Your ref:
Our ref: 22/00863/LB
Please ask for: Mrs Lesley Raby
Direct dial: 01553 616818
E-mail: borough.planning@west-norfolk.gov.uk

Details: **Listed Building Application: Retrospective External and internal works to Listed Building including demolishing works and extensions, erection of garden structure, conversion of storerooms to annexe and works to roof, change of use of land to domestic use. at Duncans Farm House Lynn Road Tilney All Saints King's Lynn Norfolk**

I have received a planning application as detailed above but cannot process it until I receive some more information:

DRAWING
SITE PLANS

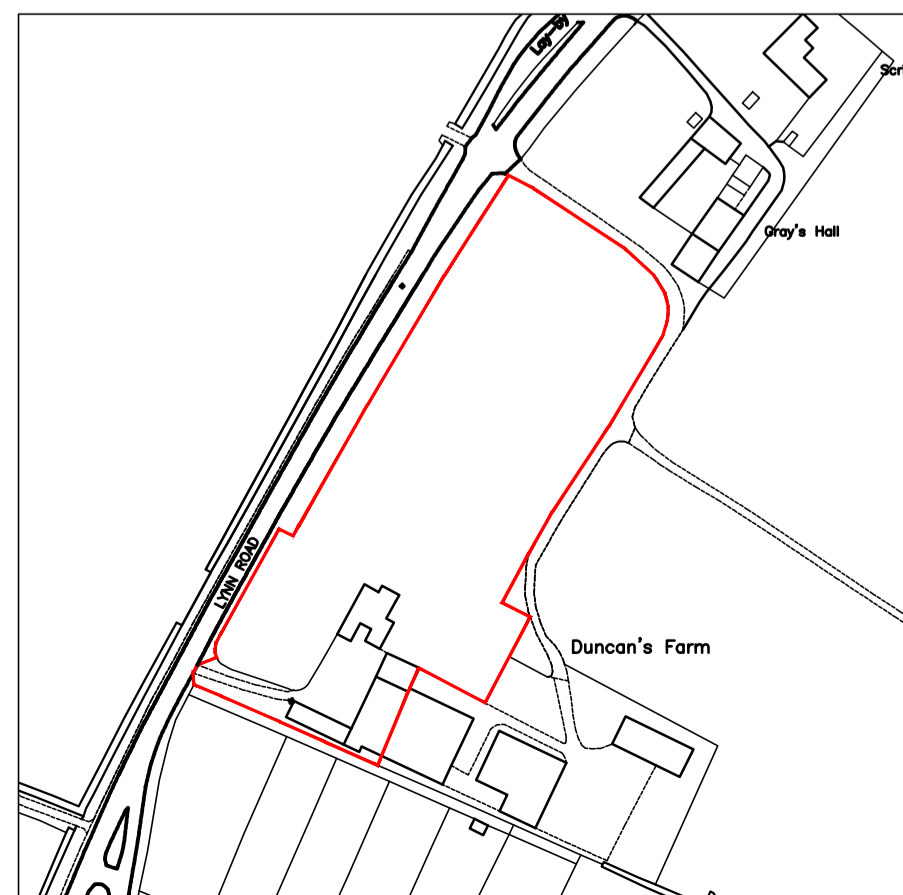
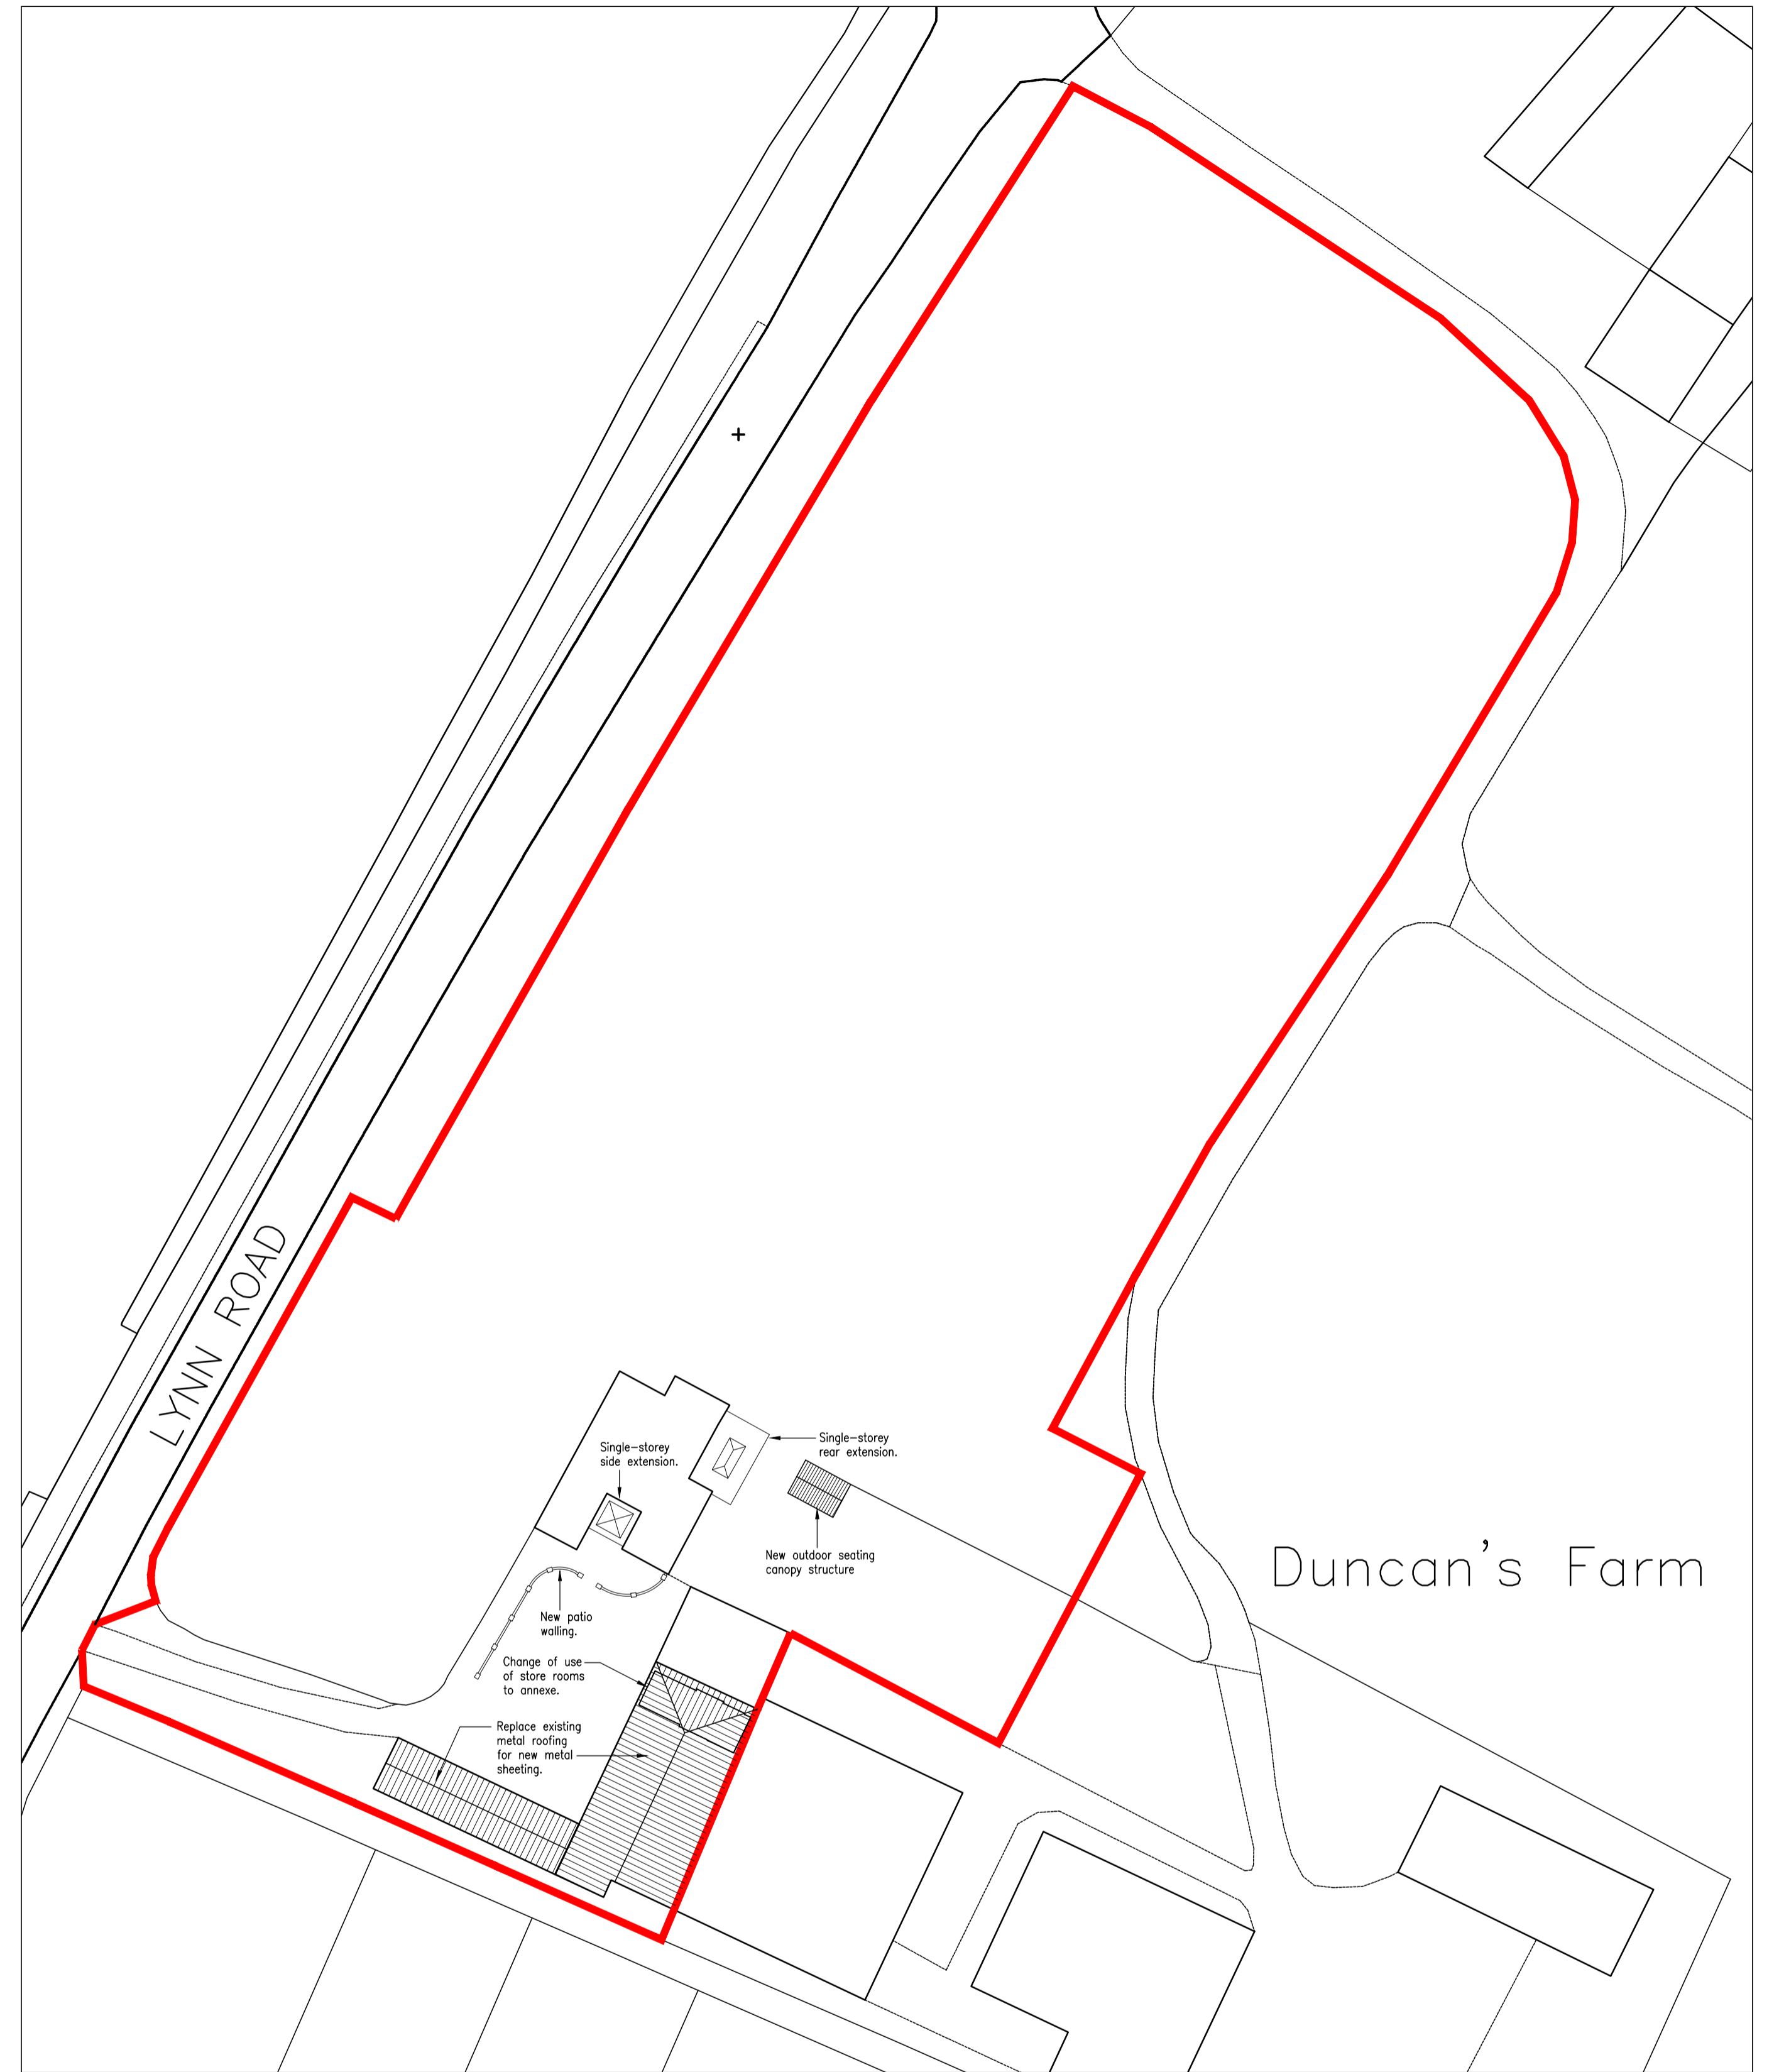
1. Provide a Heritage Statement
2. Provide a proposed block plan including a full roof plan.
